## **9.20 DGR Requirements & Responses from Authorities**

**Director General's Requirements for Global Switch Site Redevelopment (MP 08\_0222).**

<b>Application number</b>	MP 08_0222
<b>Project</b>	Construction of a new 6-storey specialist data centre building with 3 basement levels
<b>Location</b>	273 Pyrmont Road, Ultimo
<b>Proponent</b>	Global Switch Property (Australia) Pty Ltd
<b>Date issued</b>	10/2/09
<b>Expiry date</b>	If the Environmental Assessment (EA) is not exhibited within 2 years after this date, the applicant must consult further with the Director-General in relation to the preparation of the environmental assessment.
<b>Key issues</b>	<p>The EA must address the following key issues:</p> <p><b>1. Relevant Environmental Planning Instruments (EPIs) policies and Guidelines to be Addressed:</b></p> <ul style="list-style-type: none"> <li>• State Environmental Planning Policy (Major Projects) 2005</li> <li>• State Environmental Planning Policy (Infrastructure) 2007</li> <li>• State Environmental Planning Policy No. 55 – Remediation of Contaminated Sites</li> <li>• Sydney Regional Environmental Plan (Sydney Harbour Catchment) 2005</li> <li>• Sydney Harbour Foreshores &am

drwg no.
 arskDG01

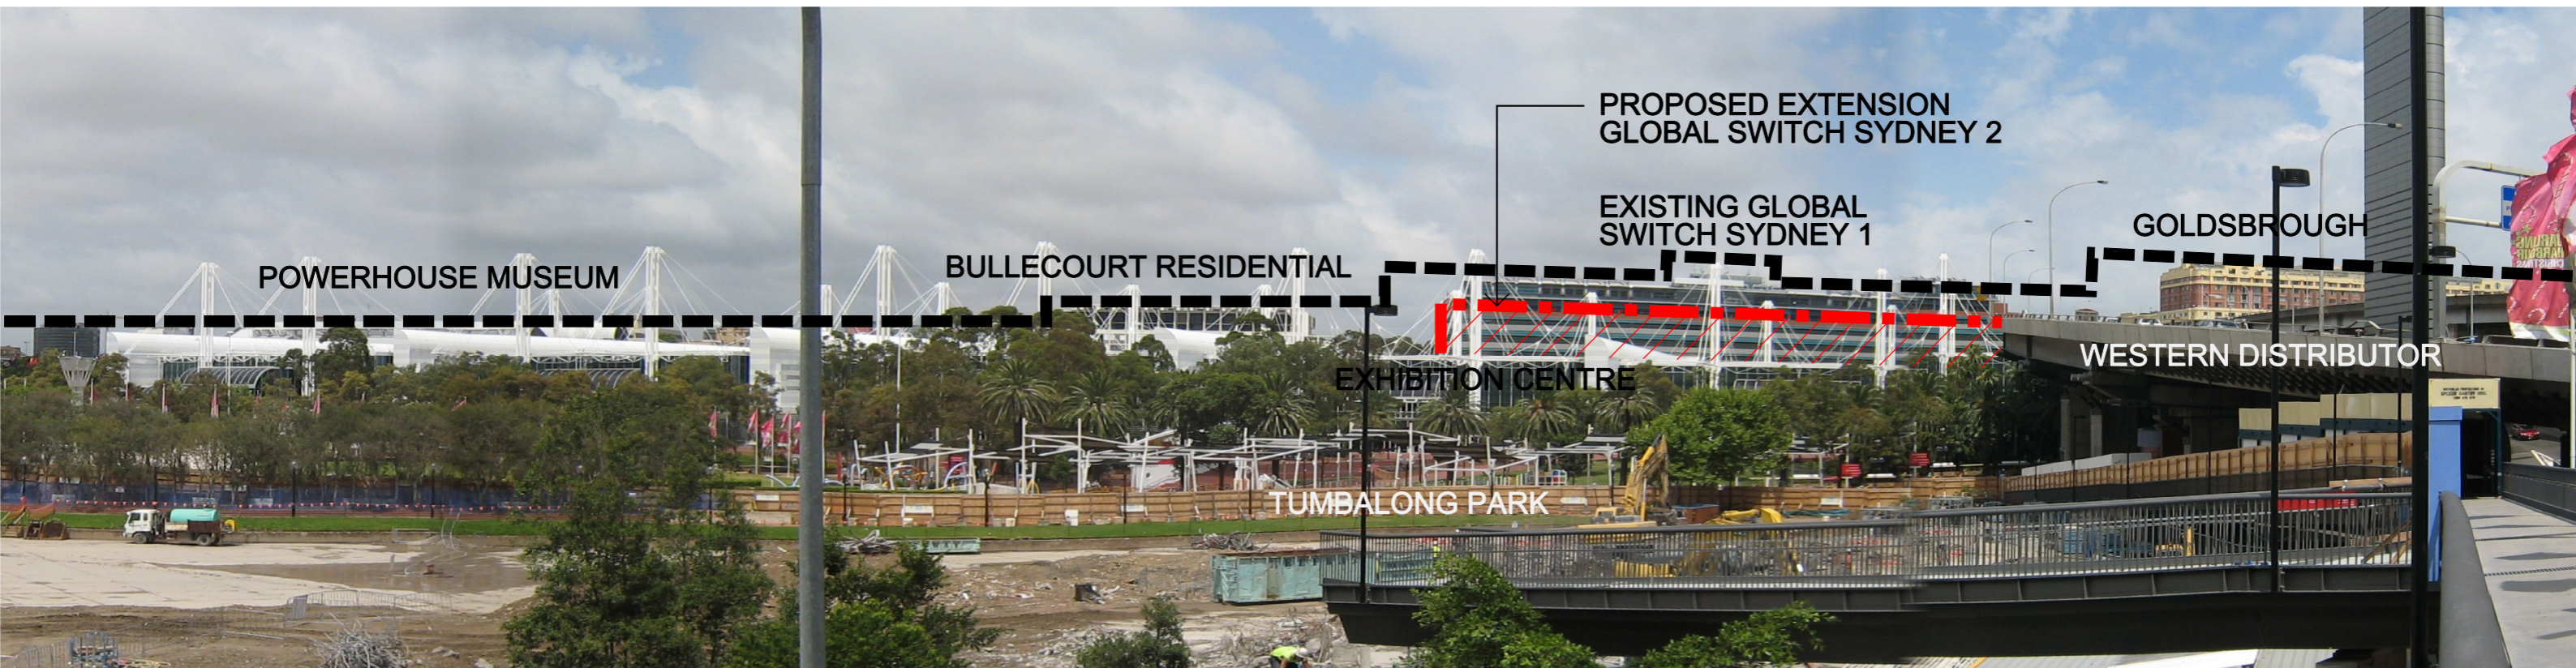
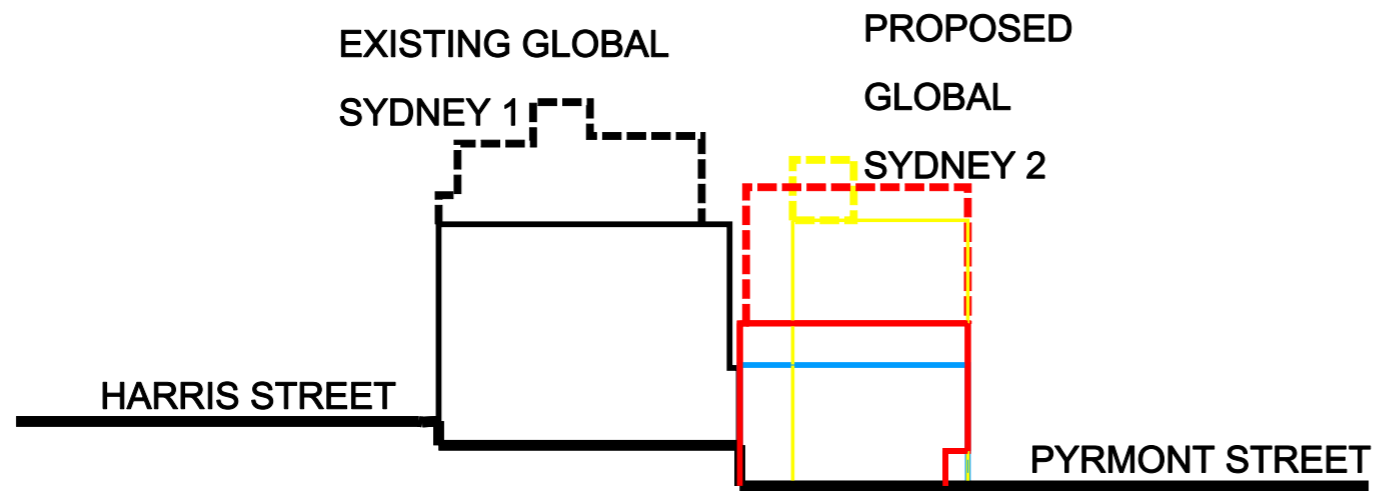
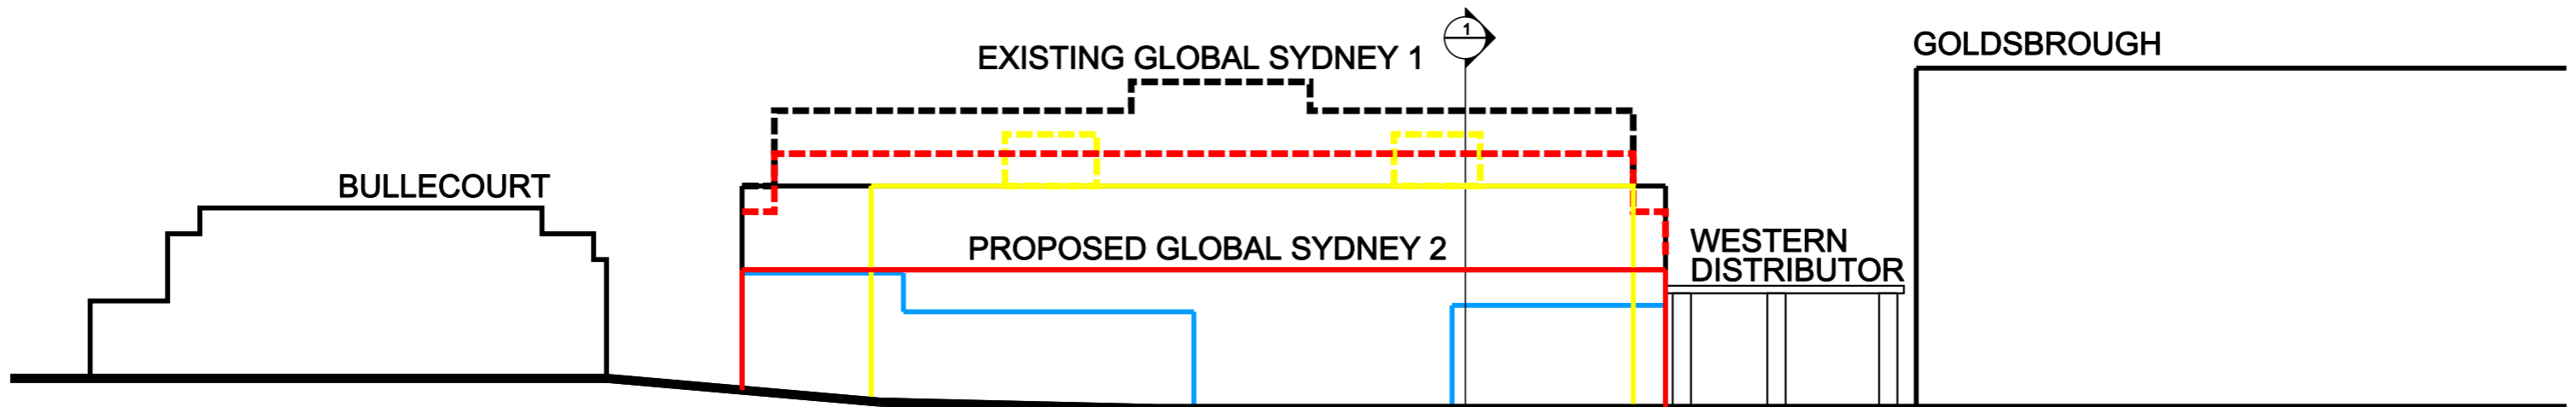
The Department also maintains concern about the height and massing of the building, and its relationship to Goldsbrough Mort, Bullecourt and the existing Global Switch developments. The proposed height of the building exceeds the prescribed height under the Master Plan. The former design for the building achieved greater design articulation, incorporating parapets set back from Pyrmont Street, and an overall lower profile. In accepting that a height greater than that of the current Master Plan may be justified, it was previously determined that any new height should not exceed the original parapet height of the GPO (Global Switch 1) building. It is appreciated that the upper levels would comprise plant areas, but these floors would still contribute to the overall mass of the building and its visual impact.
